Principal Areas of Disagreement Summary Statement (PADSS) from Surrey County Council - Version Number: Three Submitted at: Deadline Five - 6<sup>th</sup> June 2024

Figure 1: Location of Contractor Compounds

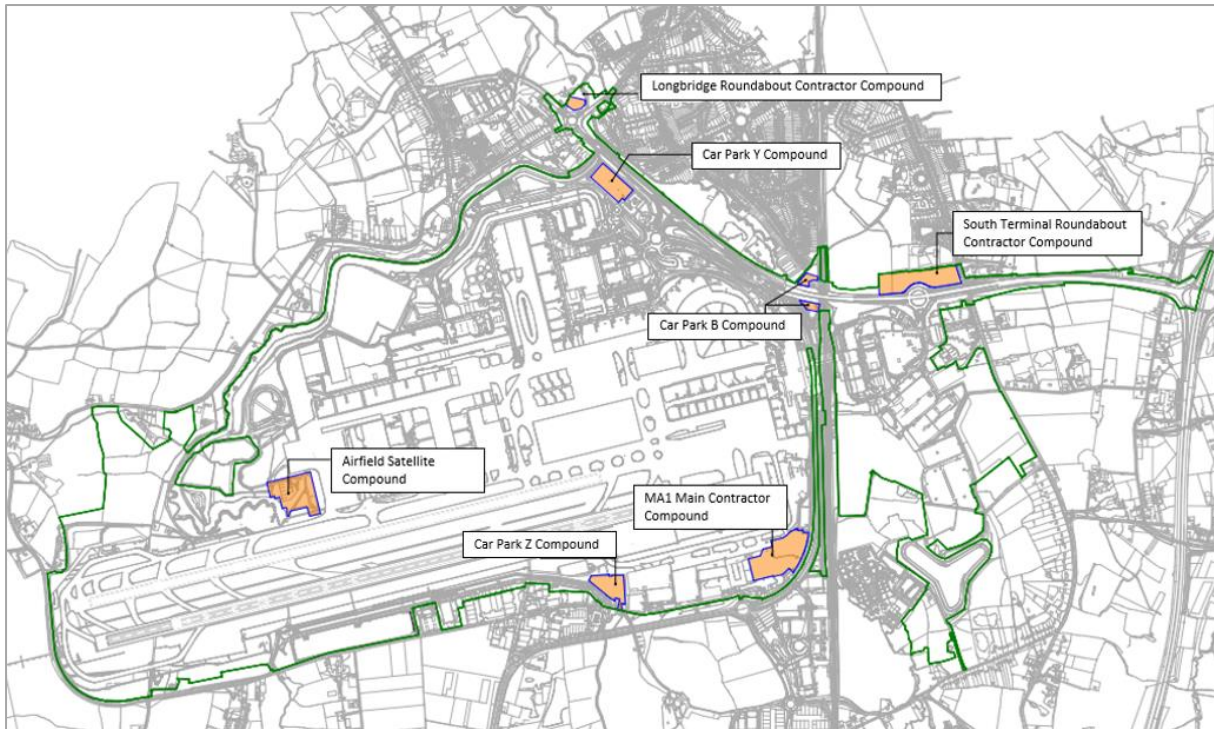
Ref	Principal Issue in Question	Concern held	What needs to change/be amended/be included in order to satisfactorily address the concern	Likelihood of concern being addressed during Examination
			scheme within the DCO. A meeting is to be arranged.	
22	Securing mitigation	The entrance to the Longbridge Roundabout compound is not defined.	SCC requests that further information is provided for the Longbridge construction compound. The existing access is considered inappropriate as detailed in the LIR.	Likely
23	Securing mitigation	SCC is concerned that separate entrances to the South Terminal compound are proposed for HGVs (from the roundabout) and private vehicles (from Balcombe Road). This implies that an extended journey on the local road network is required.	SCC wishes to see all access to the South Terminal compound from the South Terminal Roundabout. Additional detail is sought during the examination.	Uncertain
